Town & Country Planning (Control of Advertisement) (England) Regulations 2007 (as amended)

1 No. illuminated logo sign with halo lit lettering fixed to wall on front elevation.

Lovelong House 18-22 East Street Littlehampton

Visual at 10% scale

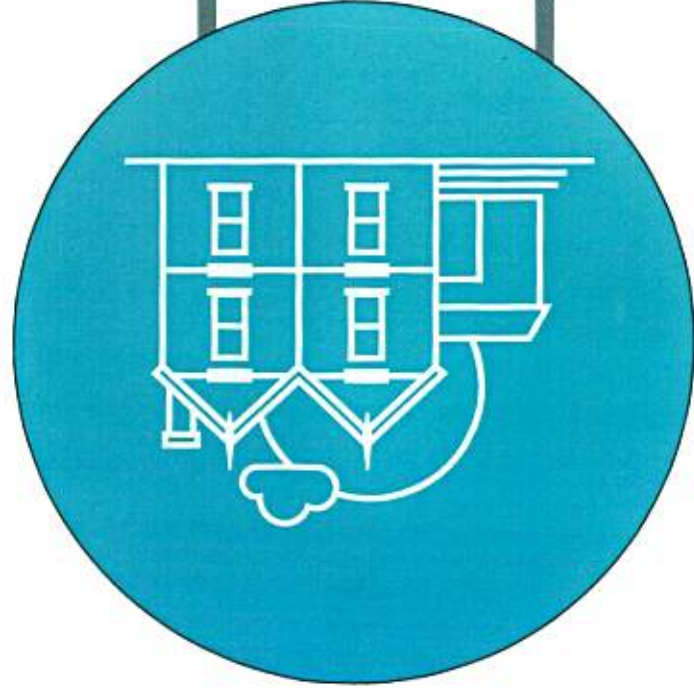
The size of this signage is all out of scale with its location in a residential road in a conservation area. In my opinion it treats the building as if it were a hoarding on a bypass. The size of lettering must be considerably reduced and does not need to be halo lit.
